# BICESTERBUG

## **Submissions on proposed housing in NW Bicester**

**21/01630/OUT**

**20 May 2022**

PROPOSED MINI-ROUNDBOUT JUNCTION PARAMETERS

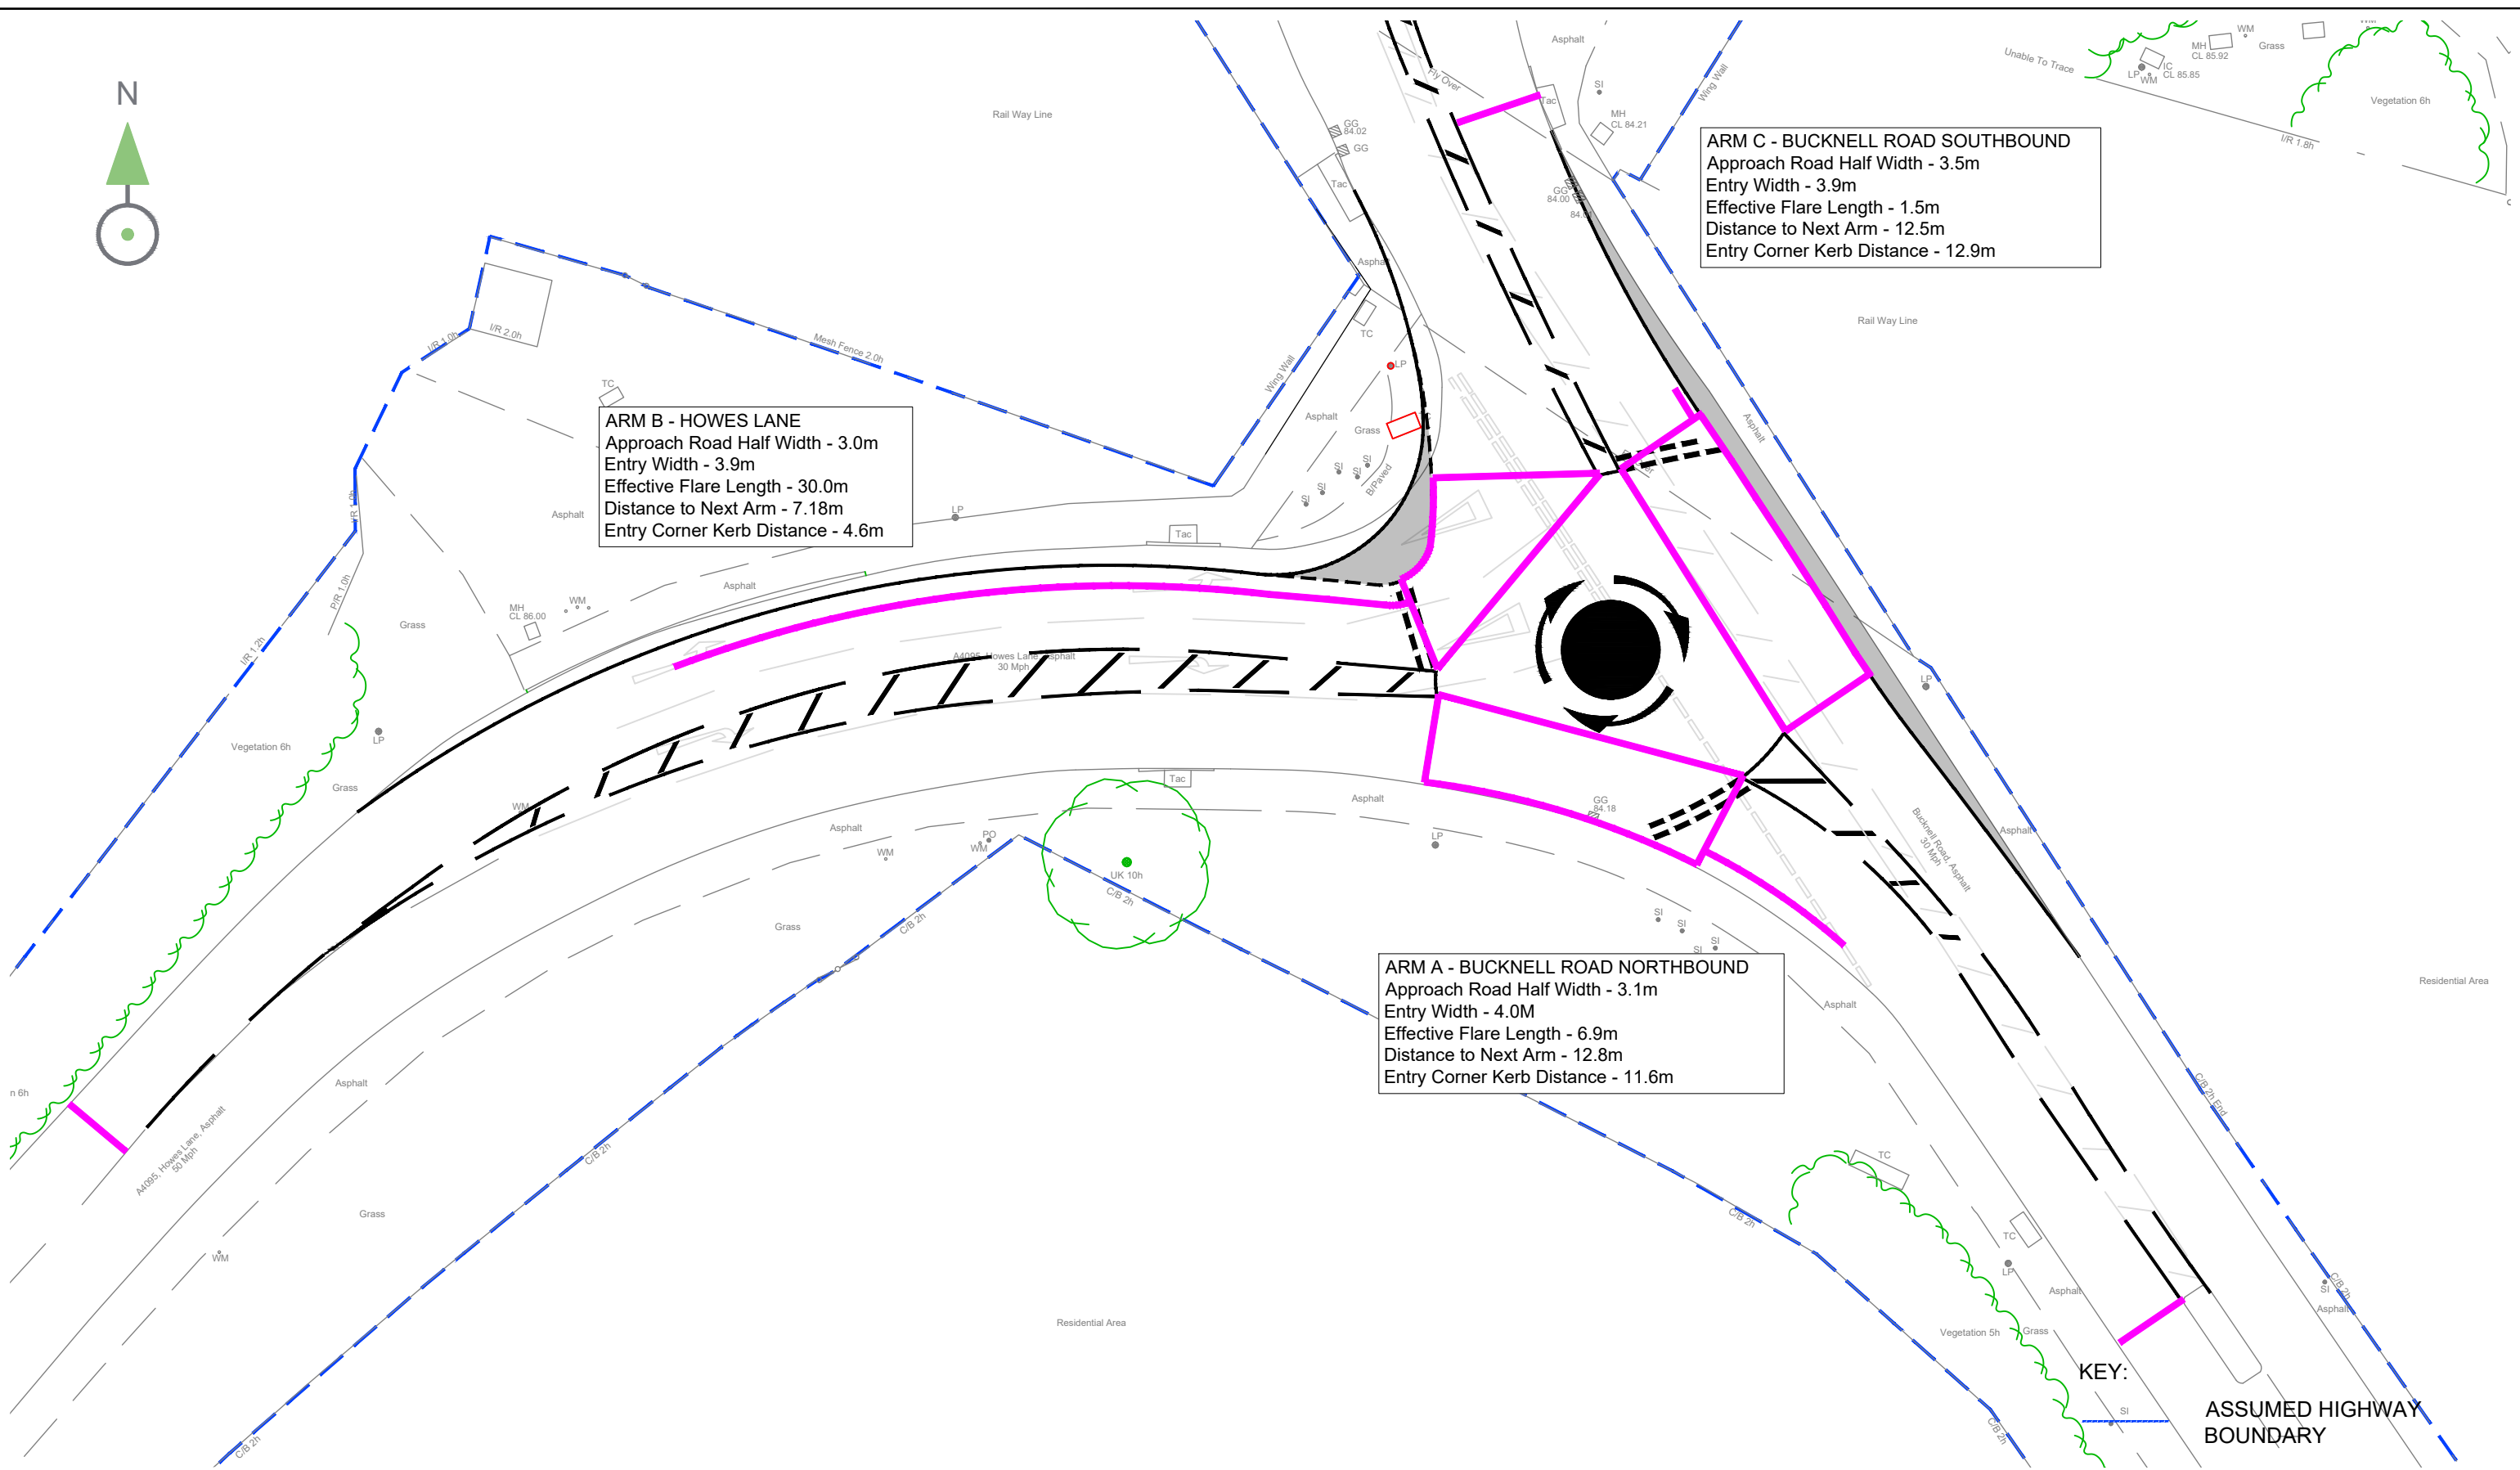
The proposed design makes no improvements to walking or cycling provision despite the increased traffic volumes. The junction forms a major access point for walkers and cyclists to access the bridleway to Trow Pool due to the bike/walking route along the southern side of A4095 north of Bucknell Road

CLIENT: Firethorn  
 PROJECT: North West Bicester  
 DRAWING: Illustrative masterplan  
 PROJECT NUMBER: I192  
 DRAWING NUMBER: SK004 CHECKED BY: MI/LA  
 REVISION: C STATUS: Draft  
 DATE: 14/04/2021 SCALE: 1:2,000

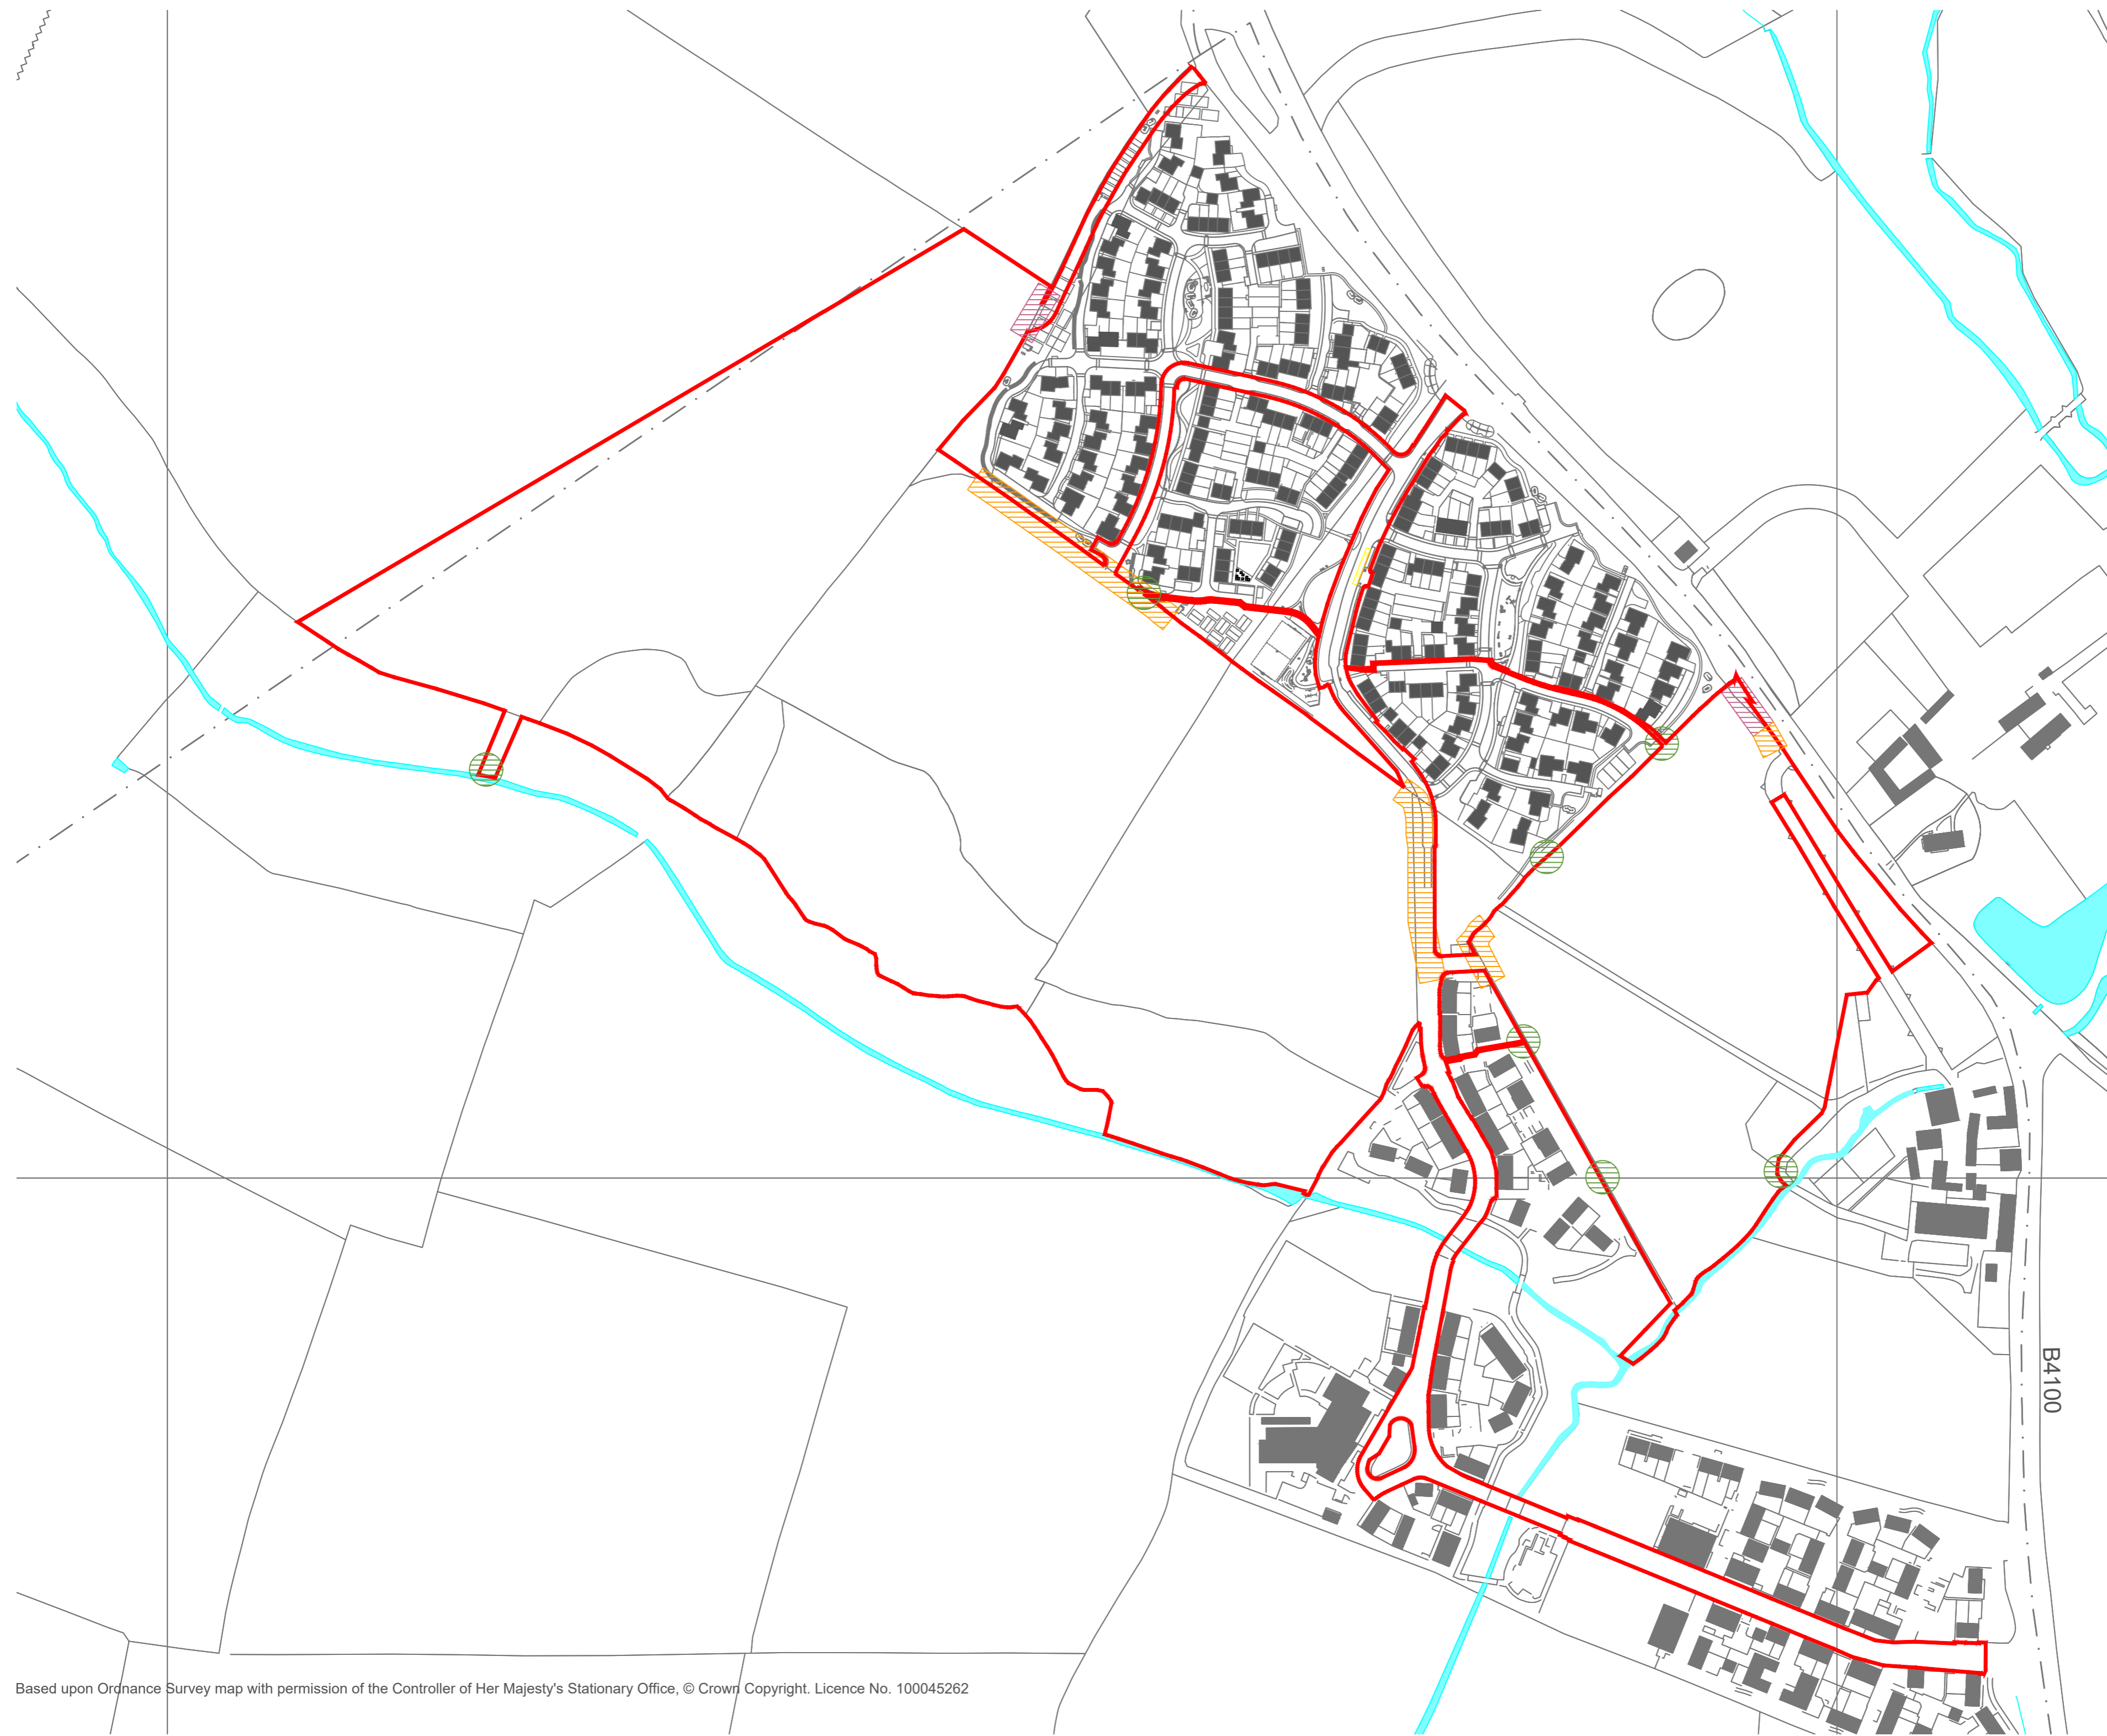
Missing connection on footpath, location in figure below.
